340 PARKDALE

Podium Massing Refinement

Response to OPA + ZBLA Comments

SOUTH ELEVATION

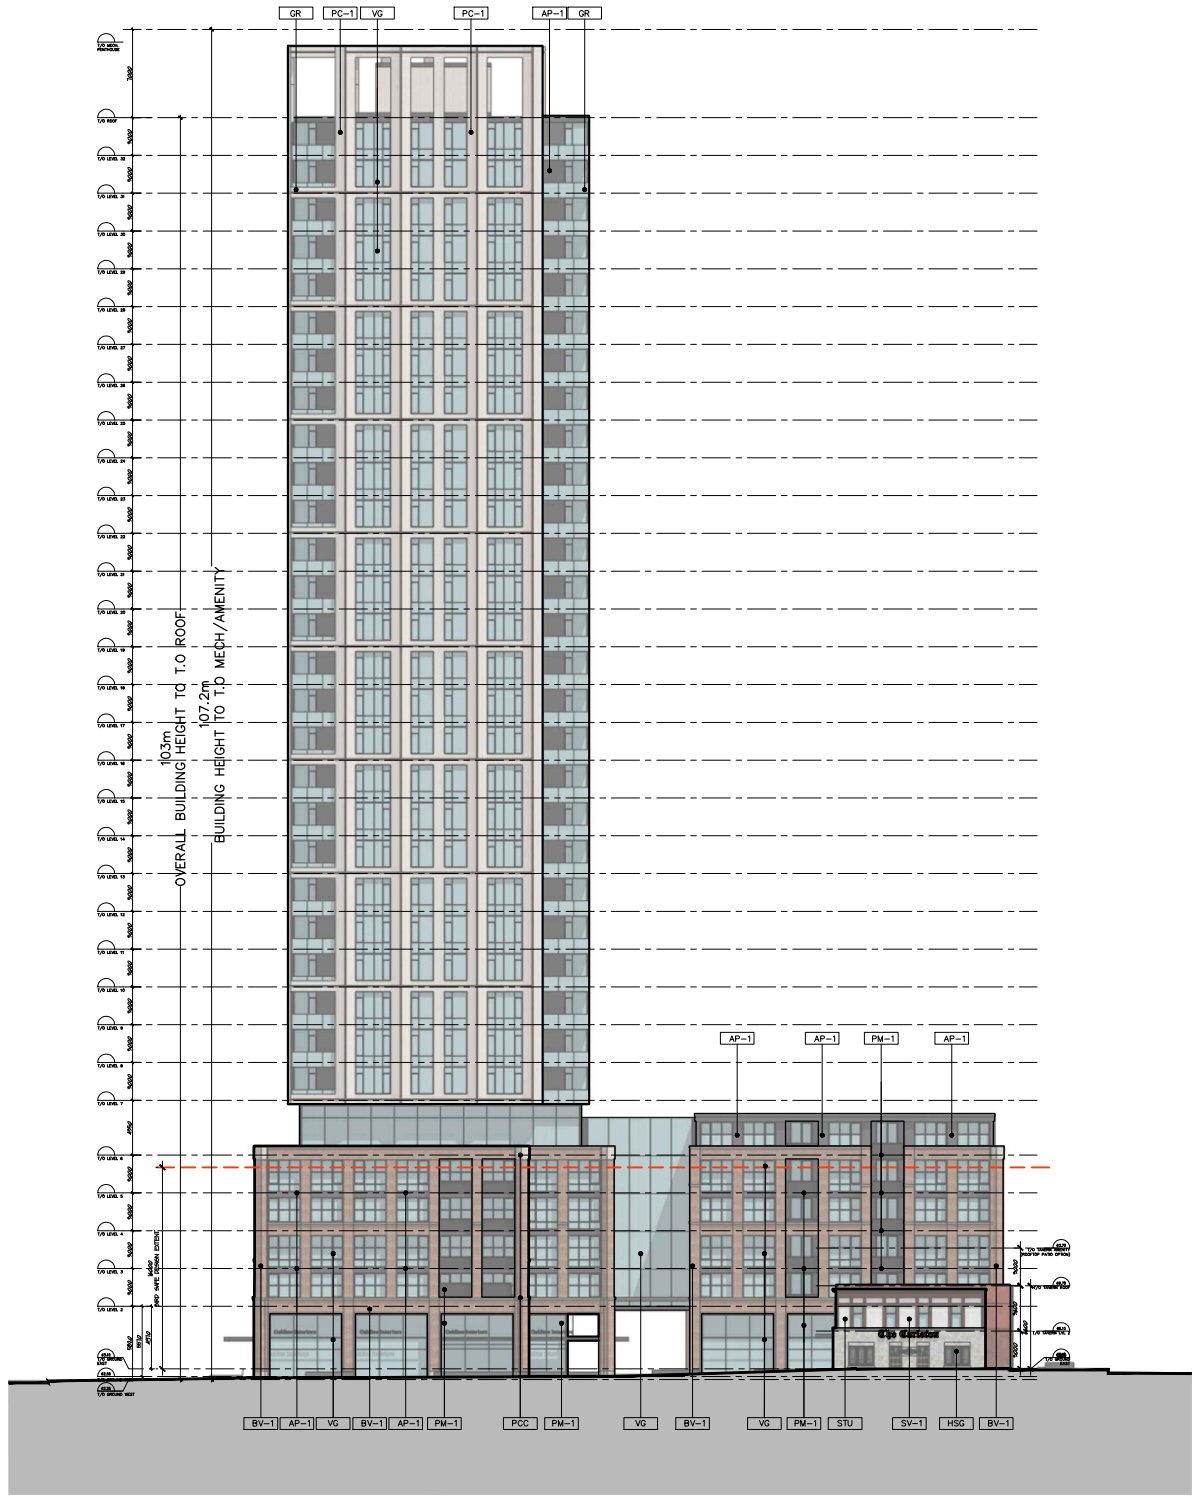
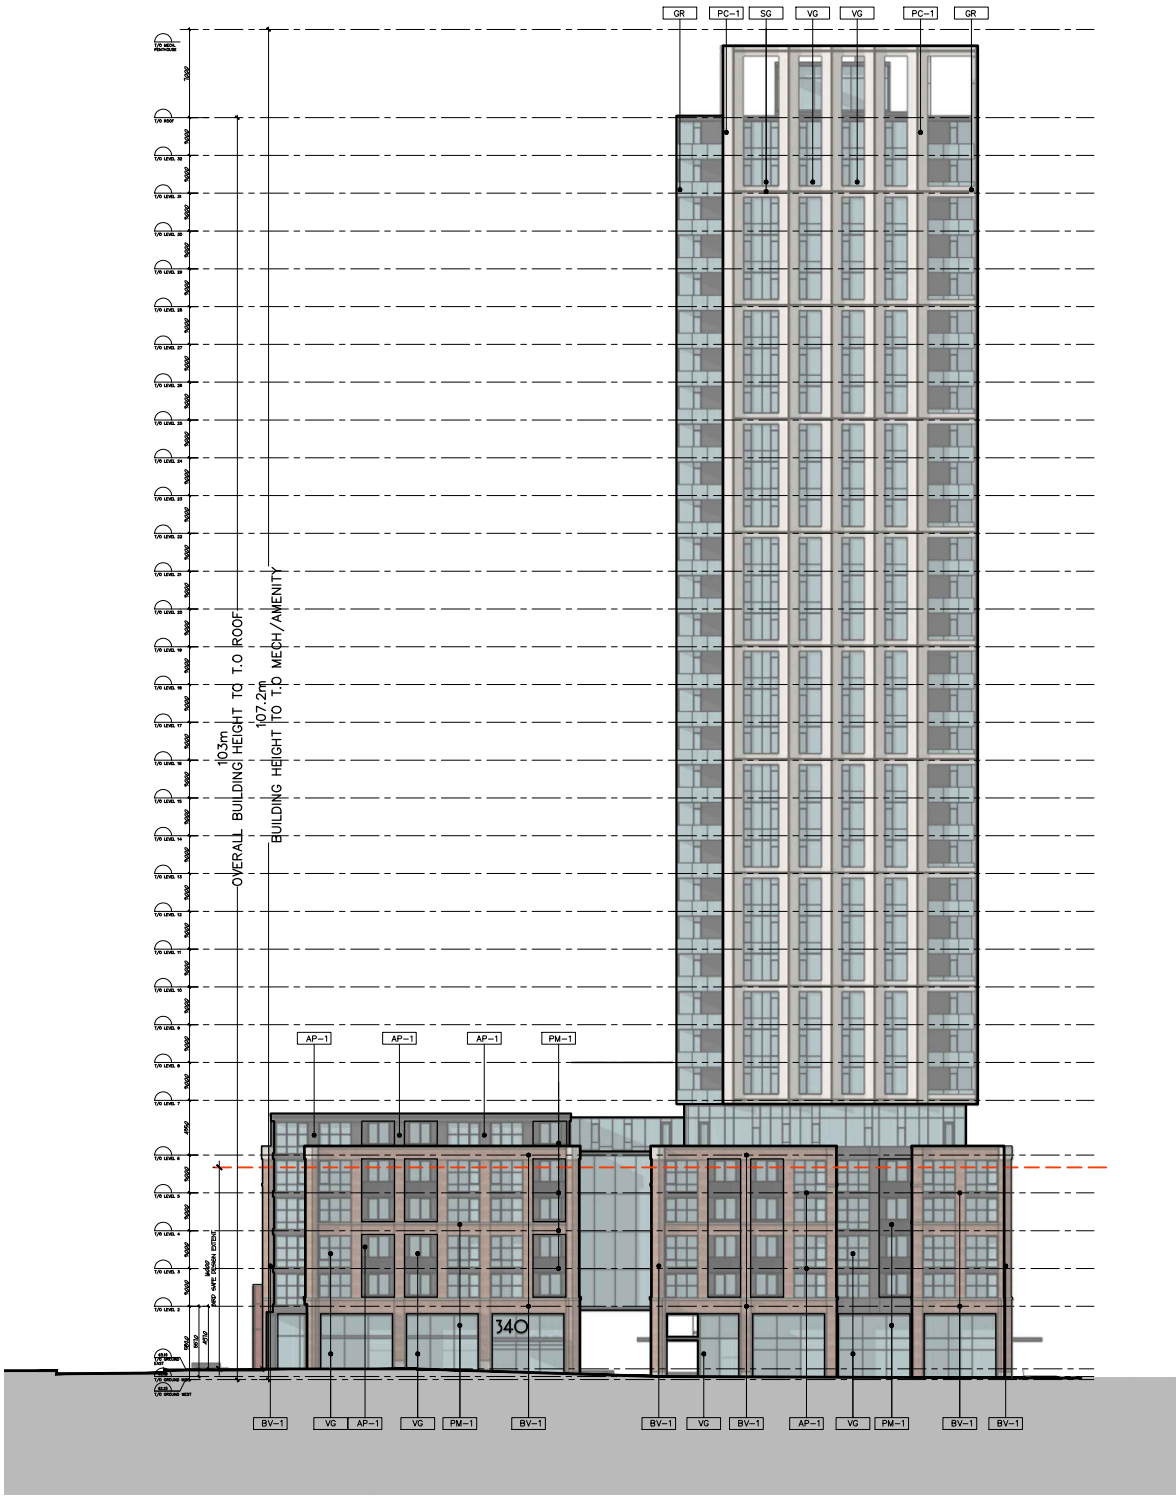
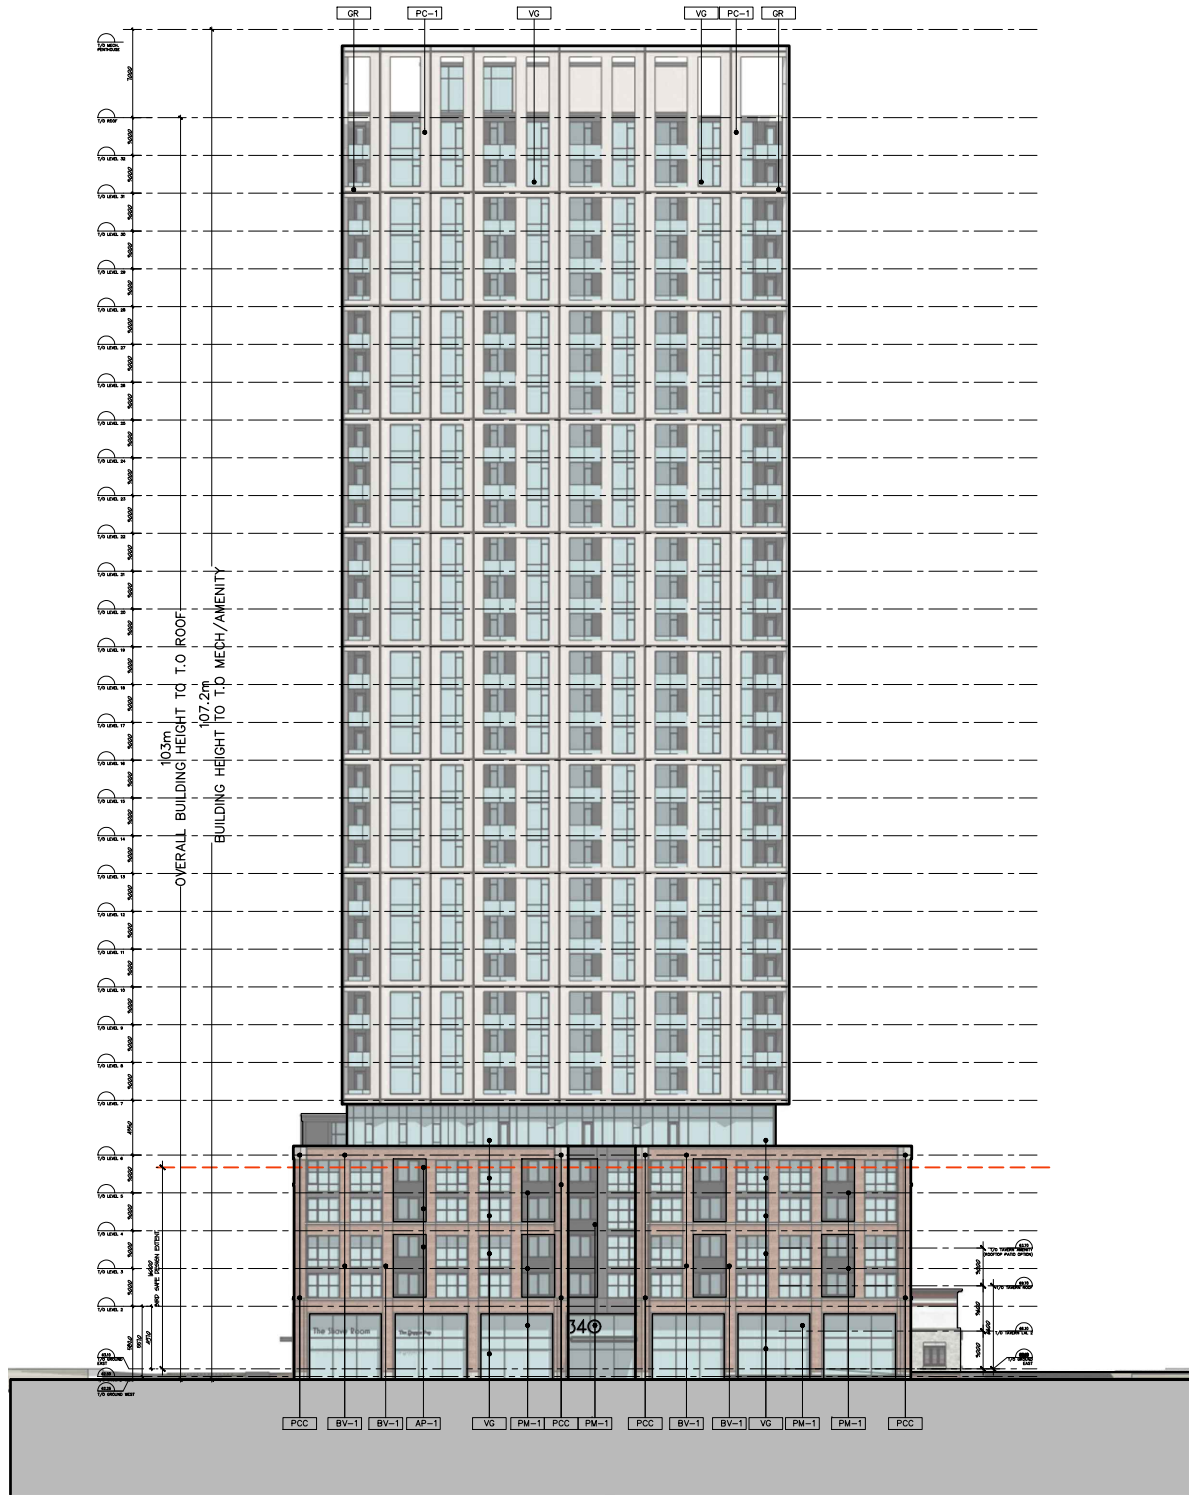
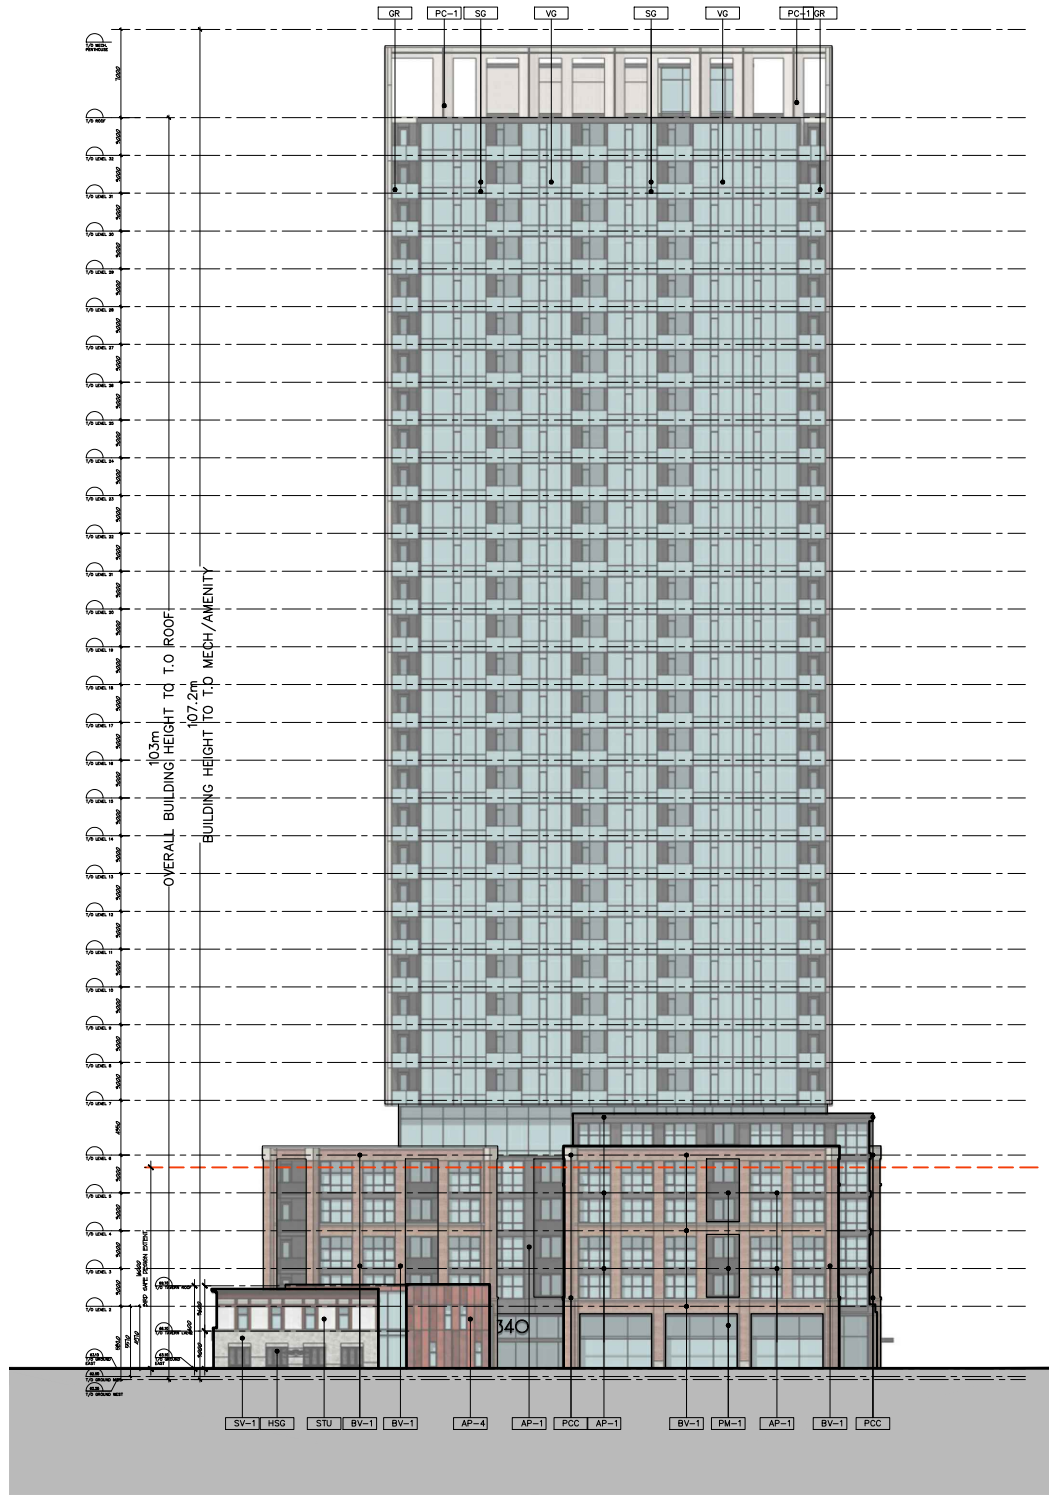
The most significant change is the removal of the two-storey “pop-up” volume previously located along the Parkdale Avenue frontage. In the earlier iteration of the design, this upper volume contained two-storey residential units and introduced additional height and visual complexity along the podium edge. This element has now been entirely removed and replaced with a more consistent arrangement of typical residential units. As a result, the eastern podium wing has been reduced from eight storeys to six storeys, while the overall podium height has been lowered by two full storeys.

Along Armstrong Street, Hamilton Street, and Spencer Street, the western half of the podium beneath the tower has also been reduced by one additional storey and is now five storeys in height. This reduction results in a substantially lower and more human-scaled streetwall condition. Facing Armstrong Street and the Parkdale Market, the revised five-storey mass establishes a scale that is more compatible with the surrounding neighbourhood fabric and reinforces a stronger pedestrian relationship with the public realm. The lower streetwall creates a more comfortable sense of enclosure and better aligns with the intent of the Official Plan's emphasis on pedestrian-oriented design, transition, and contextual fit within Inner Urban areas.

A strong visual datum has also been introduced through the extension of the red heritage-inspired brick façade up to the fifth level around the podium. This consistent horizontal expression establishes a clear streetwall scale, visually anchors the building to the surrounding context, and reinforces the podium base as a cohesive element. The datum line helps establish a stronger relationship to adjacent buildings while creating a more pedestrian-scaled reading of the mass.

Along Hamilton Street, the podium has been organized into a series of distinct building components while maintaining consistency in the streetwall to align with the character to the west.. A brick mass anchors the Armstrong/Hamilton corner, while a darker industrial aluminum volume at mid-block creates a visual separation and emphasizes the primary residential entrance. A secondary brick volume wraps the Hamilton/Spencer corner and is again separated through darker recessed elements. These breaks create rhythm and variation along the streetscape while reducing the perceived scale of the overall podium. Together, these design approaches speak to the established character to the immediate north at 45 Spencer.

Along Spencer Street, the building expression is further divided into a series of distinct blocks, giving the impression of multiple smaller buildings rather than a single continuous structure. This approach reflects the existing pattern of development in the area and reinforces the finer-grain urban character currently present on the site and within the surrounding neighbourhood. The eastern Parkdale wing is read as a separate building component and is distinguished through a glazed link element located above the breezeway, creating a visual break between masses and further reducing the apparent scale of the podium.
